Your ref: 3/2018/0024

Date: 1st February 2018

Planning Application 3/2018/0024: Conversion and extension of redundant piggery and store to one single-storey dwelling including access and parking; Outbuildings adjacent to Hammond Drive, Read BB12 7RU

GROUND FLOOR
EXISTING FOOTPRINT 180m²

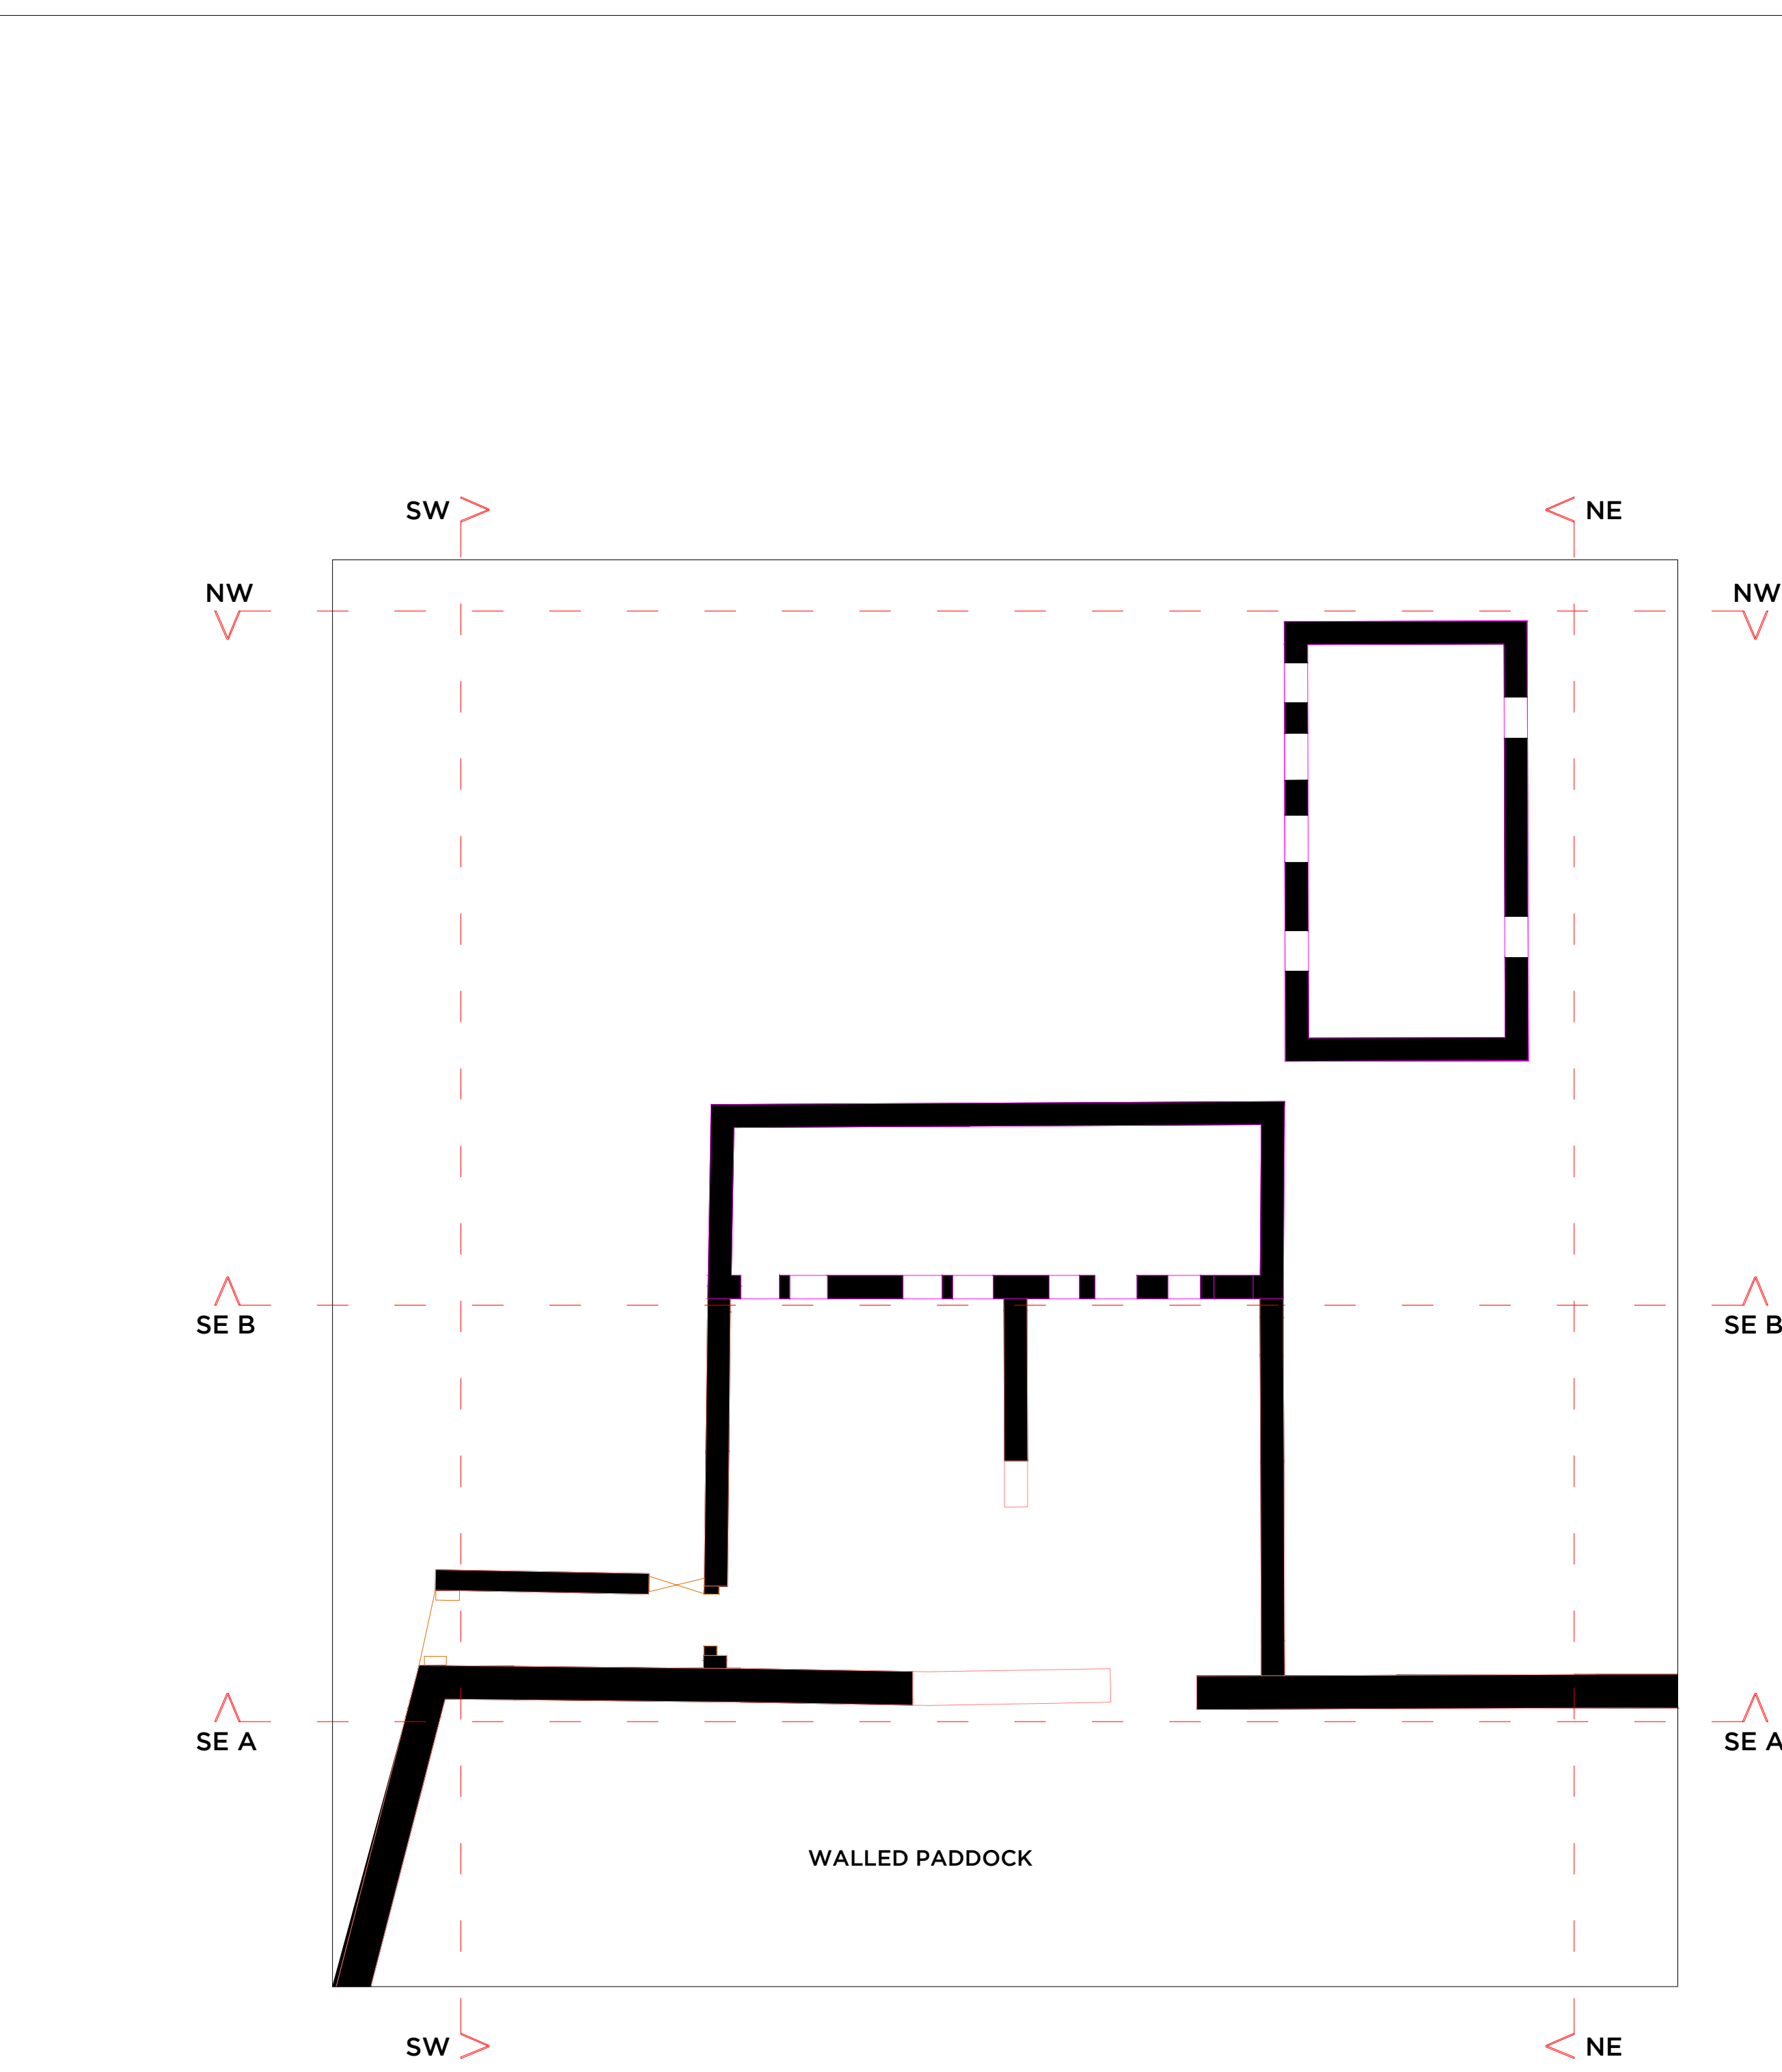
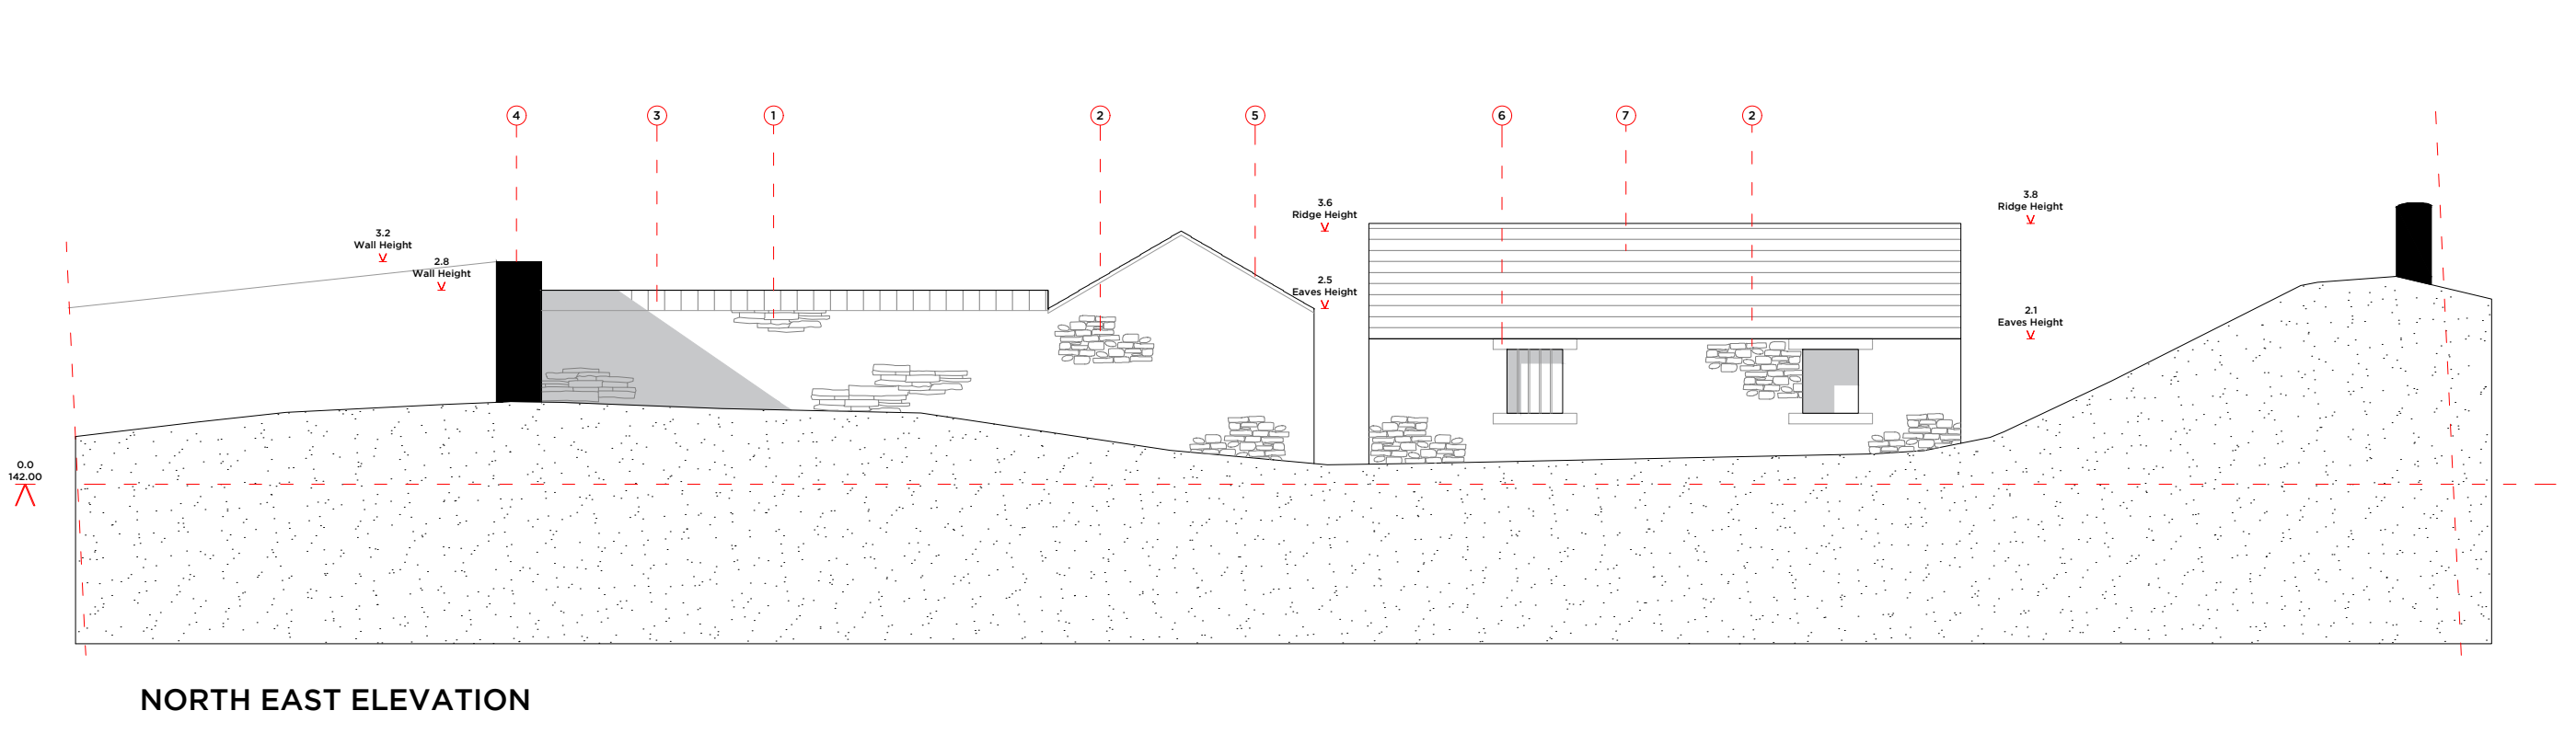
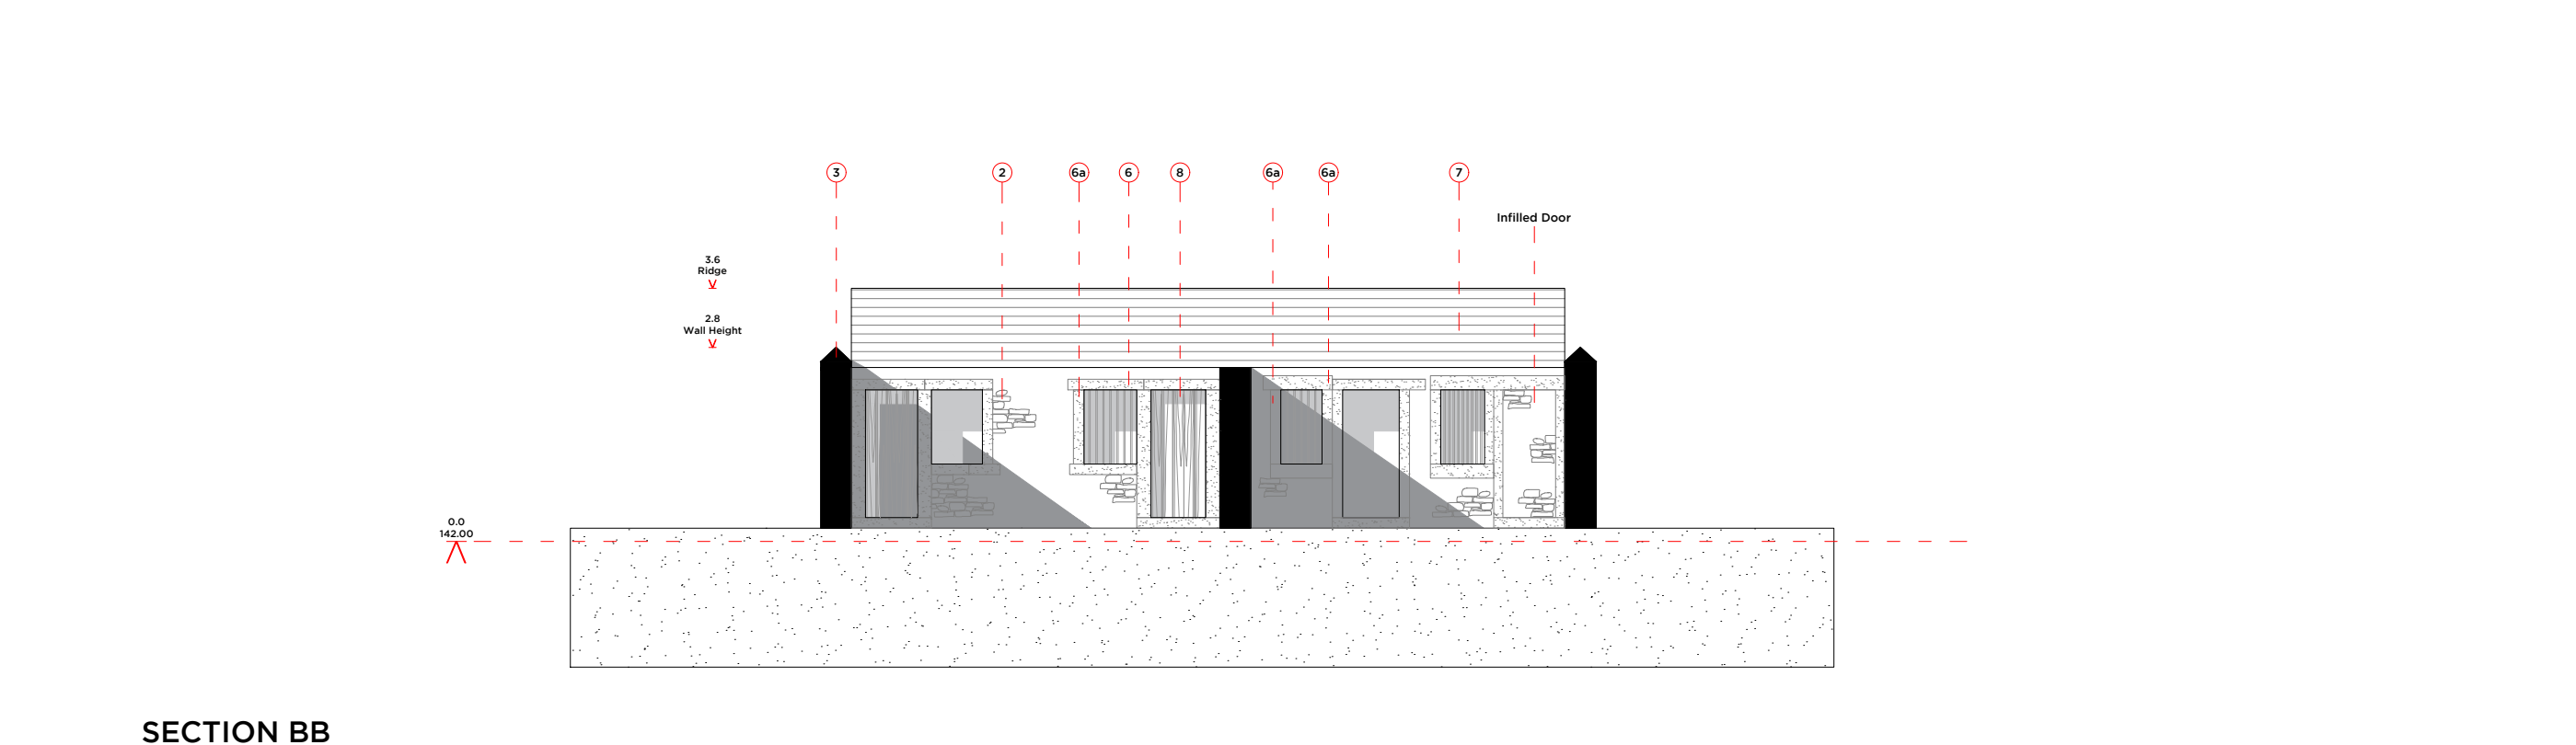
The application is accompanied by plans of the buildings as existing, a Heritage Impact Assessment (HIA, Richard K Morriss and Associates, December 2017) and a Planning Proposal document (Inspire Planning Solutions, nd). Whilst there are a few anomalies and typographical issues within the HIA it does not appear fatally flawed. As it notes the structures proposed for conversion are worthy of consideration as non-designated heritage assets (section 6) and a brief history of the area (unreferenced) and description of the site is provided. The HIA concludes that "*The scheme will result in some internal changes and some minor loss of fabric, but that is not considered to cause harm to the significance ...*" (HIA section 9). We would note that the proposed conversion will actually require the rebuilding and repair of some elements of walling and openings, underpinning works, the erection of new walls and roofs to increase the habitable floor area, the dry-lining of all habitable spaces, the insertion of a number of roof lights, the lifting of existing floors and the insertion of insulation and damp-proofing, as well as the installation of all modern services. New stud partitions are required in the northern building, but it is not clear if the existing divisions in the southern building (HIA section 5.1.1.03) are to be retained or replaced – the supplied plans 'as existing' do not show

them and the drawings in the Planning Proposal (pp.30-31) suggest that new stud walls are proposed there.

Overall the impact level of the proposed works on the extant structures could be considered to be moderate to high, rather than minor as implied in the HIA. The significance of this impact, however, is offset by the late date and relatively low importance of the structures, as well as the extant screening of the site. It would probably be assessed as 'minor negative' if Environmental Assessment methodologies were used. Given this, we would not object to the proposals as set out and if on balance the Council decides to grant permission to the application, would only recommend that some minor recording work be undertaken as a condition of any consent. This recording work should comprise the creation of a formal photographic record of the structure, the checking and correcting of the architect's plans and elevations 'as existing' (above), and the checking and correction of the HIA, followed by their submission to the Lancashire Historic Environment Record. It is probable that collecting together the photographs already provided with the application and supplementing them with a small number of detailed photographs showing the (internal and external) faces of the walls not already illustrated, plus an appropriate plan showing the photograph's location and orientation, will be all that is needed in respect of the photographic record.

- (i) The creation of a photographic record of the structures as set out in 'Understanding Historic Buildings' (Historic England 2016). It should be undertaken prior to any development work commencing.
- (ii) The checking and any necessary revision of the architect's plans 'as existing' (Peter Hitchens Architects PHA/088-300, January 2018).
- (iii) The checking and any necessary revision of the Heritage Impact Assessment provided by Richard K Morriss and Associates (December 2017)
